## COMMENT RESPONSE NARRATIVE

DATE: June 20, 2023  
PROJECT ARCHITECT: ELEVEN18 ARCHITECTURE, PL  
CONTACT NAME AND NUMBER: Matt Conte, AIA LEED AP | 407-745-5300

PROJECT NAME: **The Springs of Ballentine**  
PERMIT NUMBER:

PLEASE NOTE THE FOLLOWING REVISIONS TO THE PROPOSED SET OF DRAWINGS HAVE BEEN COMPLETED IN RESPONSE TO THE NORTH CAROLINA DEPARTMENT OF HEALTH AND HUMAN SERVICES FOR THE ARCHITECTURAL REVIEW DATED 4/12/2023 AND MEP REVIEW DATED 6/7/2023 AS WELL AS CITY COMMENTS DATE 6/13/2023.

**A303**  
 BUILDING SECTIONS

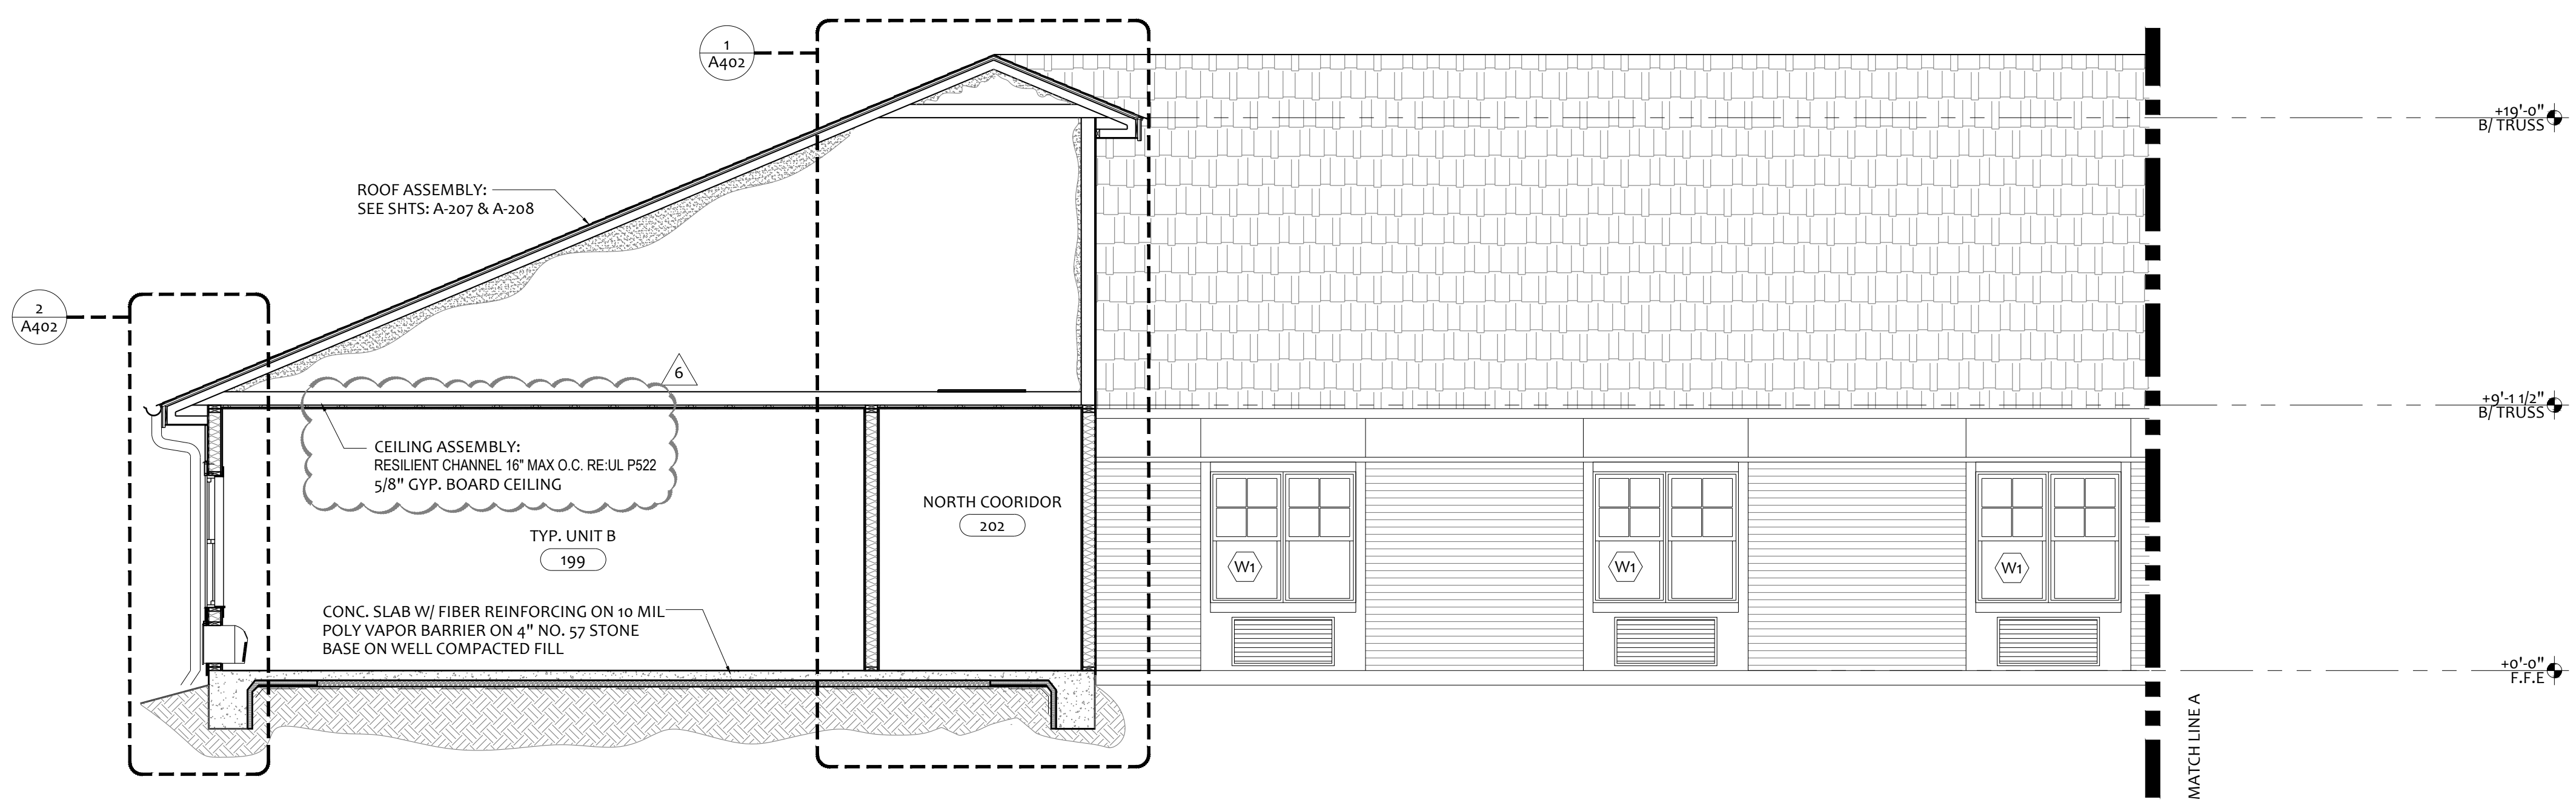
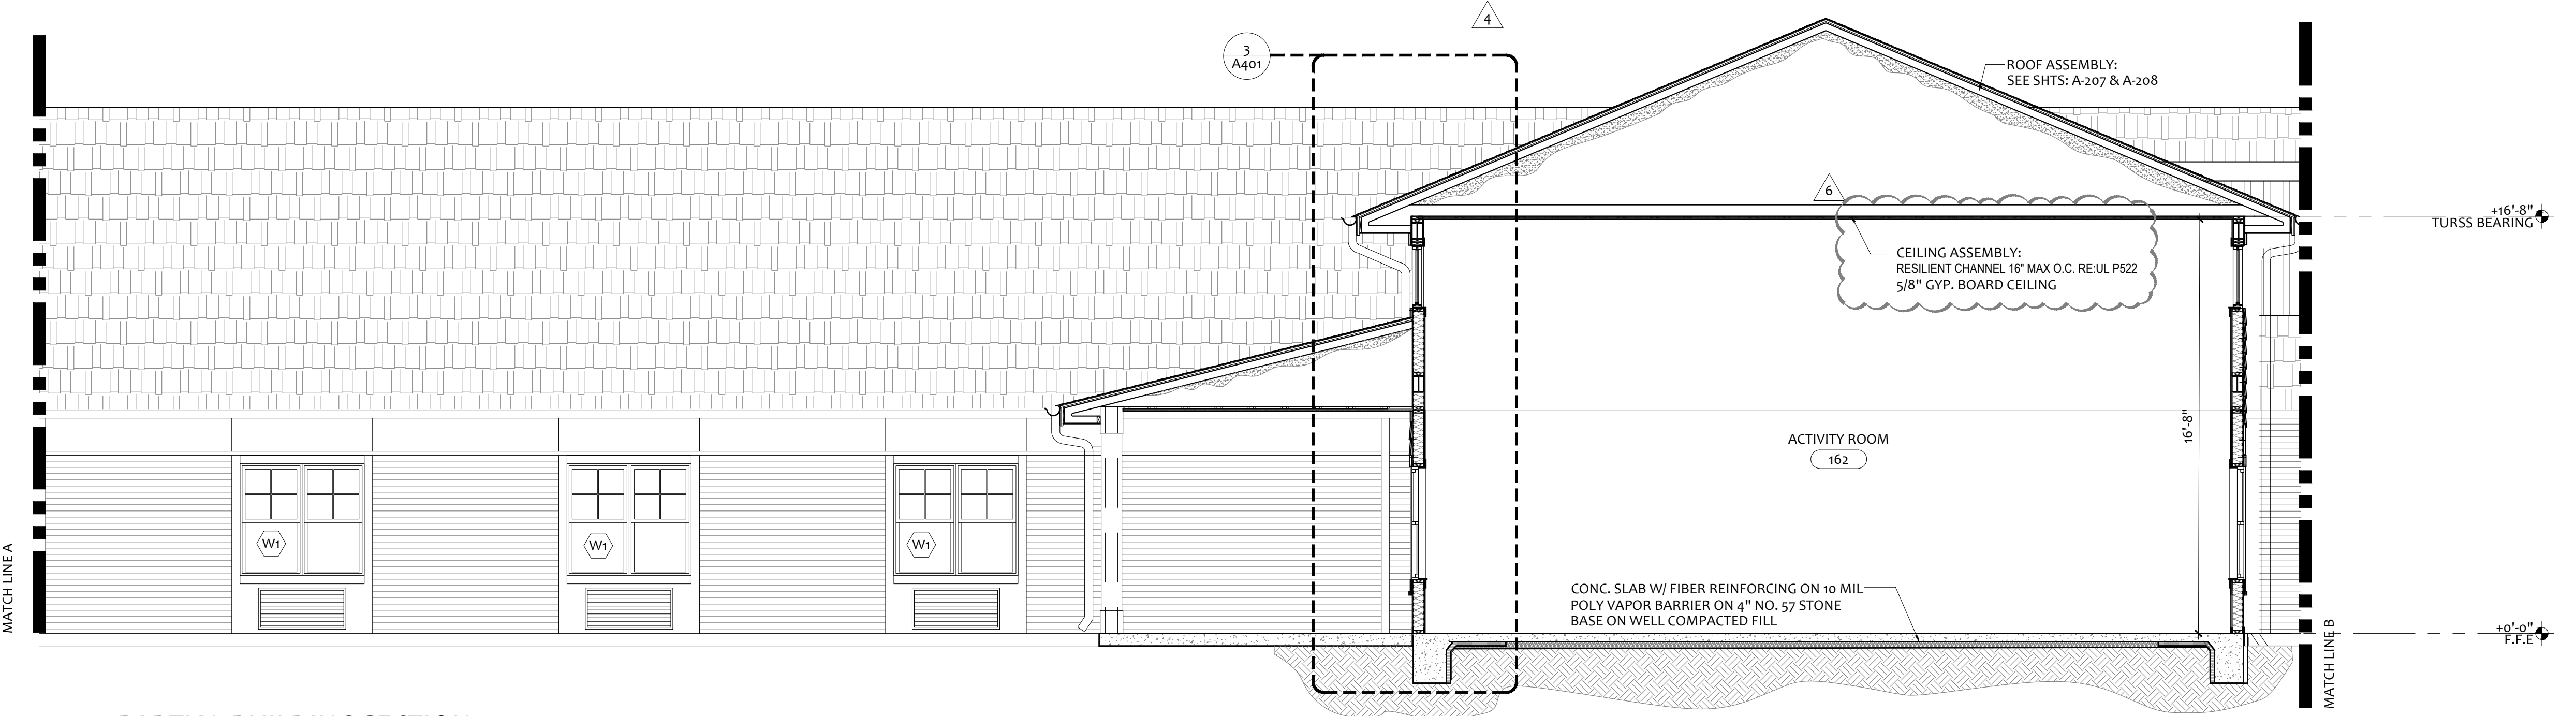
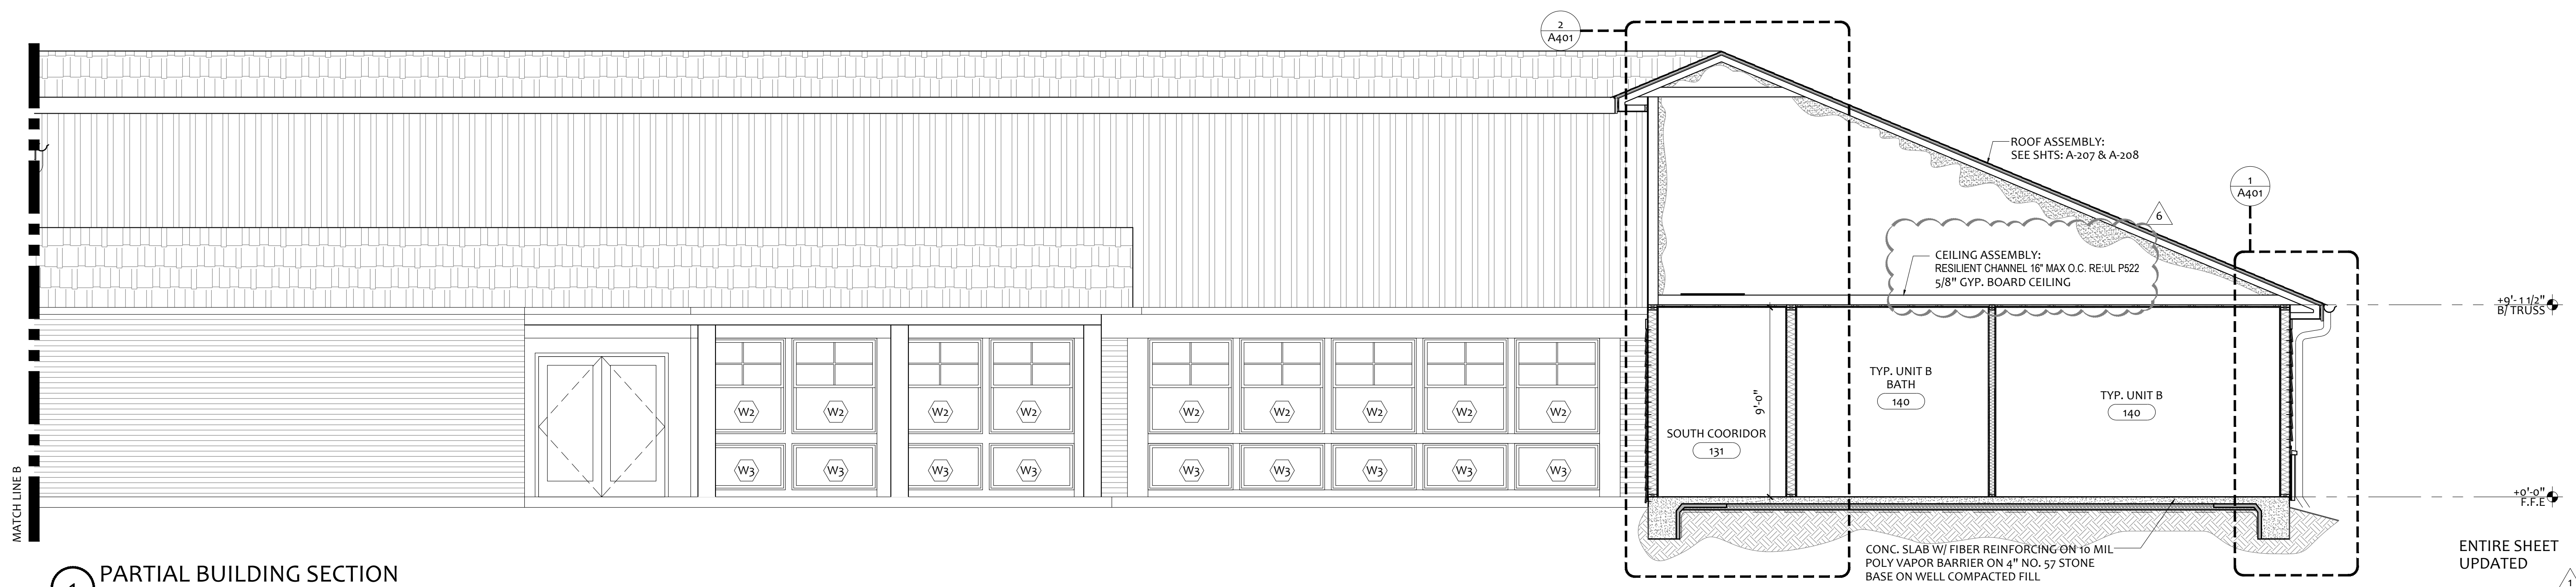
**3. The 1-hour roof ceiling assembly P522 on Sheet A006 was tested with specific products. Please submit confirmation that that specific product was used if this assembly is used with the 16" on center resilient channels.**

**RESPONSE:** P522 on sheet A006 has been moved to sheet A013 per revision 4. All sections and details have been updated from "hat track" to "resilient channel." Refer to revised sheets A302 – A305 and A401-A405. If another alternate product is used as part of P522 the contractor/architect will submit that information to the AHJ.
